Recommendation Report for Planning Permission

REF NO: BR/314/18/PL

LOCATION: Abbots Lawn
Sylvan Way
Bognor Regis
PO21 2RS

PROPOSAL: Front 1st floor extension over residents lounge to provide 4 No. bedrooms & link extension.

sheet 2 a of 6

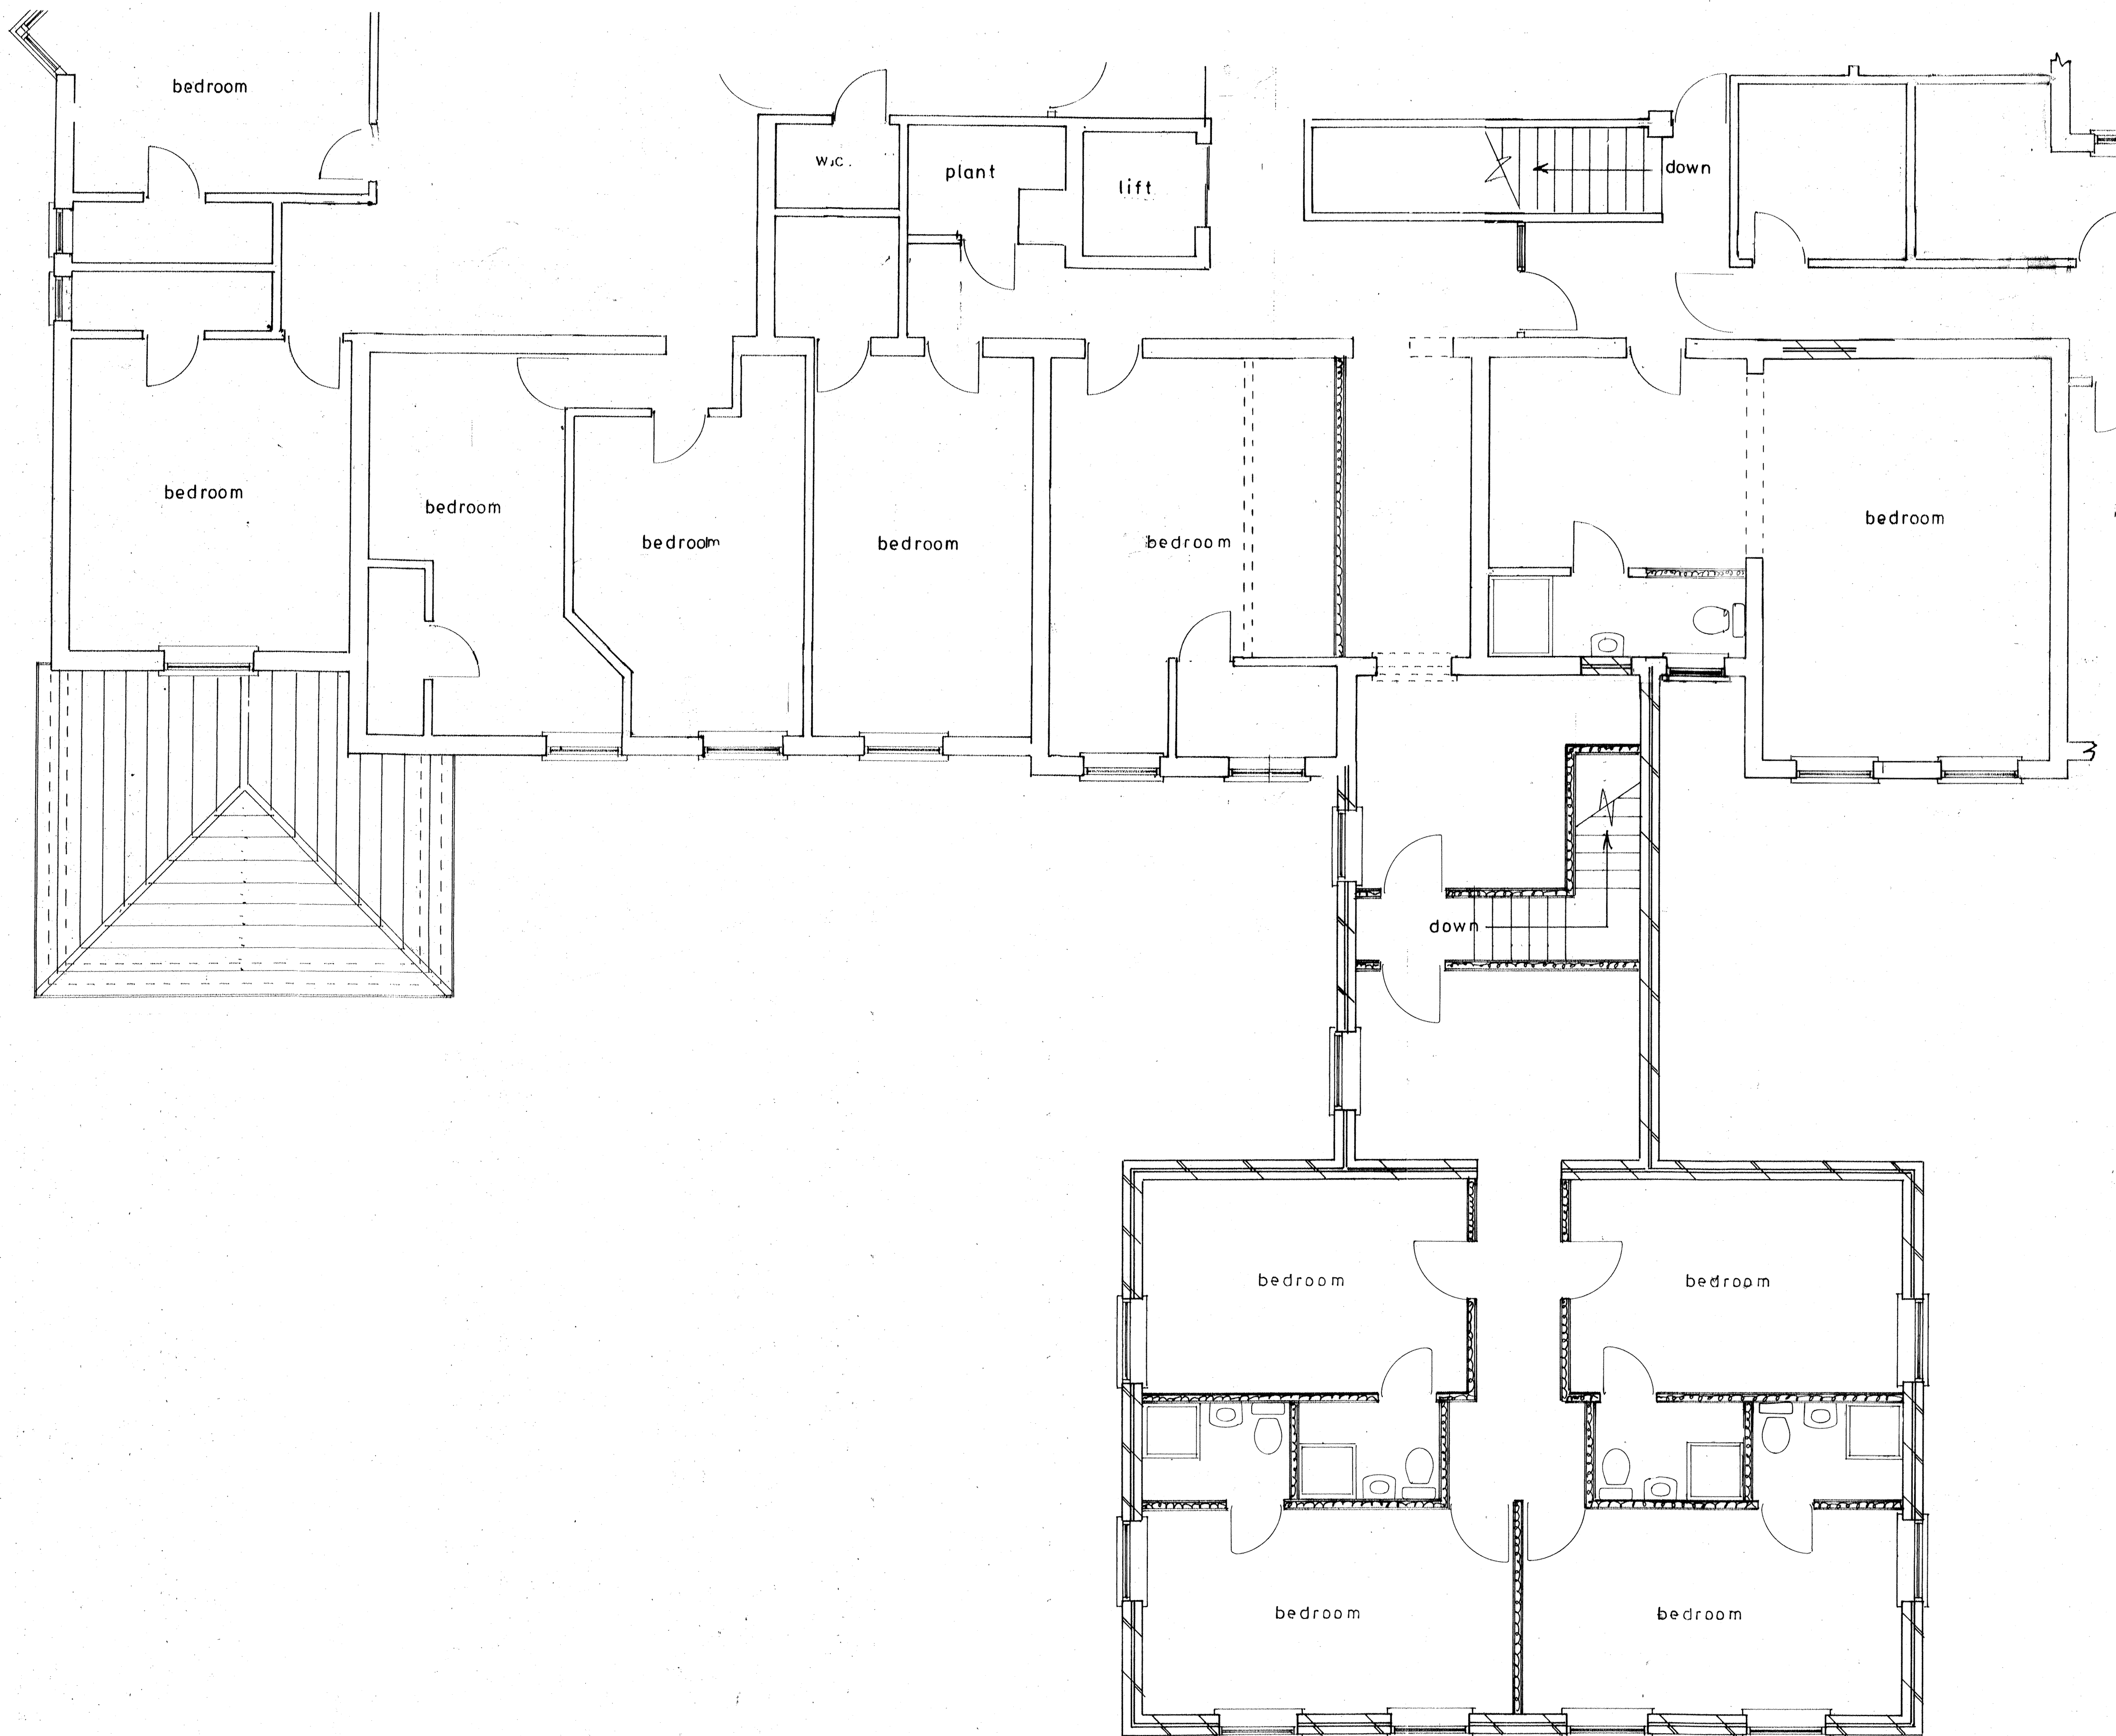
With regards to violation of a privacy of the occupiers of properties to the east, it is considered that the proposed first floor windows facing to the north would not cause any significant loss of privacy given the substantial separation distance of more than 20m between the proposed extension and the residential properties to the east. To avoid overlooking of the private gardens obscure glazing condition will be imposed. Noise pollution would not materially increase.

Sheet 2a: 'Proposed First Floor Plan'

sheet 3 b of 6

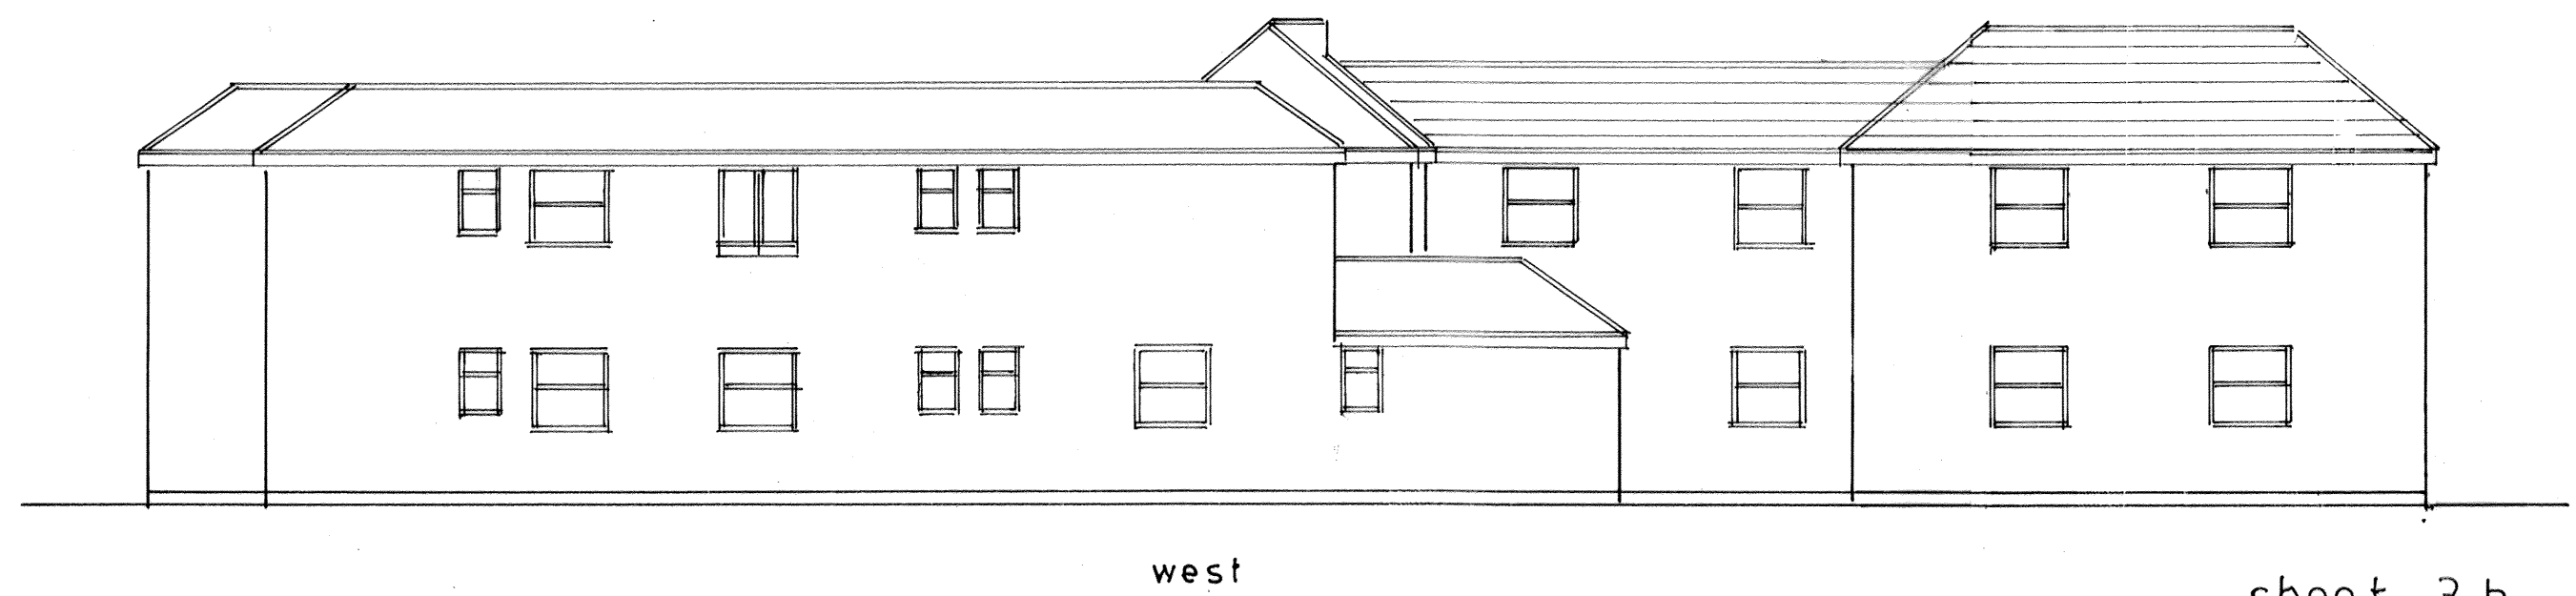
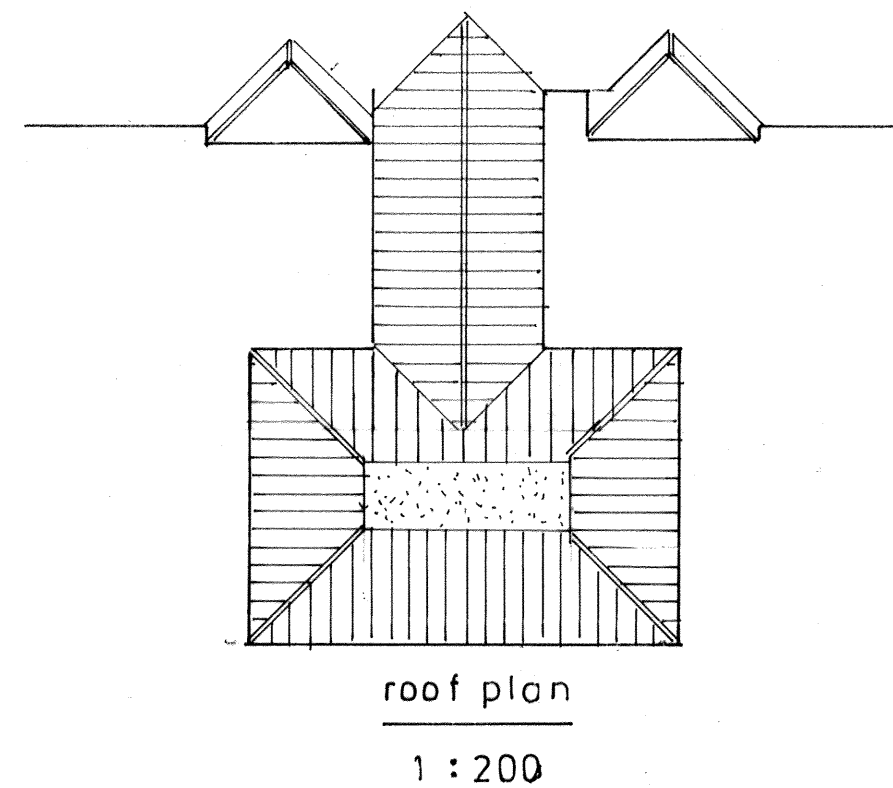
The extension is an addition to the first floor of an existing front projection and would have only a modest impact on the street scene due to its position and design and would be situated within a substantial separation distance of at least 20 m from the nearest neighbouring habitable rooms windows where it would not harm their amenities. The privacy of the gardens to the private gardens to the east will be secured by obscure glazing condition.

- 4 The first floor window on the eastern elevation of the proposed extension serving to the bedroom facing to the road shall at all times be glazed with obscured glass fixed to be permanently non-opening.

sheet 7 a of 7

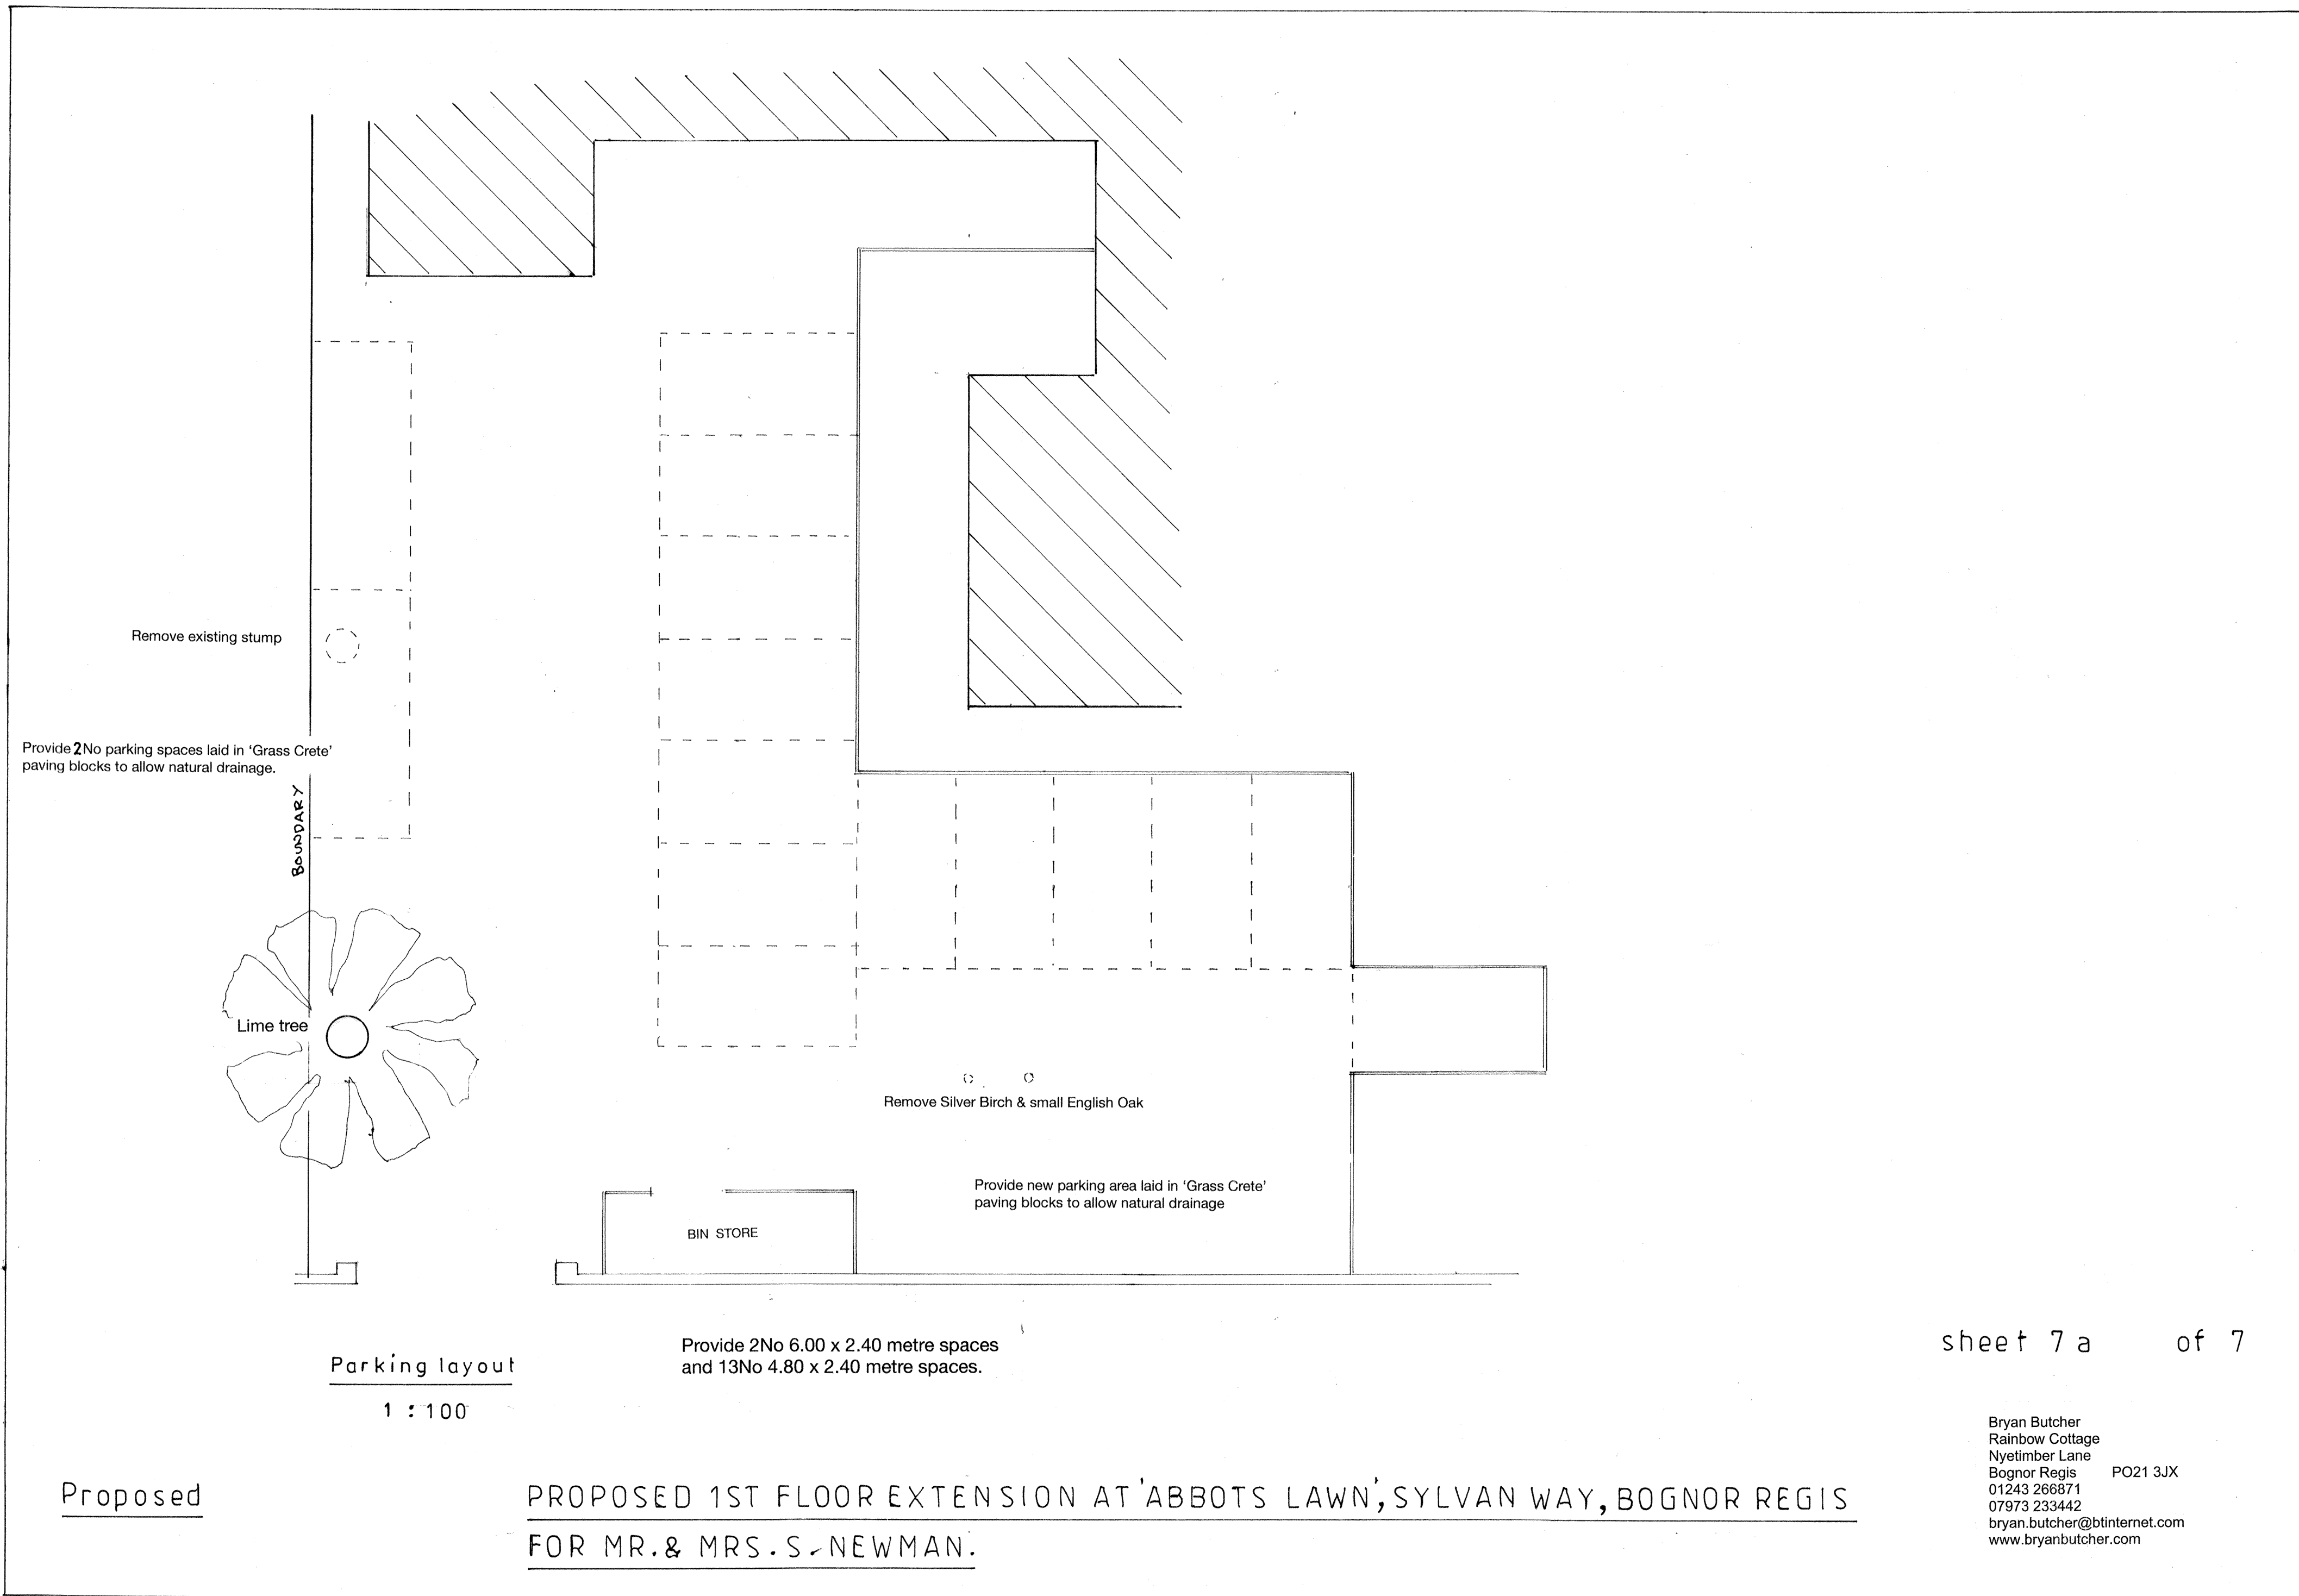
The agent has provided the parking layout showing an adequate provision of parking spaces.

Submitted drawings show provision of 15 parking spaces, according to the requirement of West Sussex County Council guidance and agent provided Arboricultural Method Statement; (BS:5837)

Sheet 7a: 'Proposed parking Layout', received on 23/08/2019
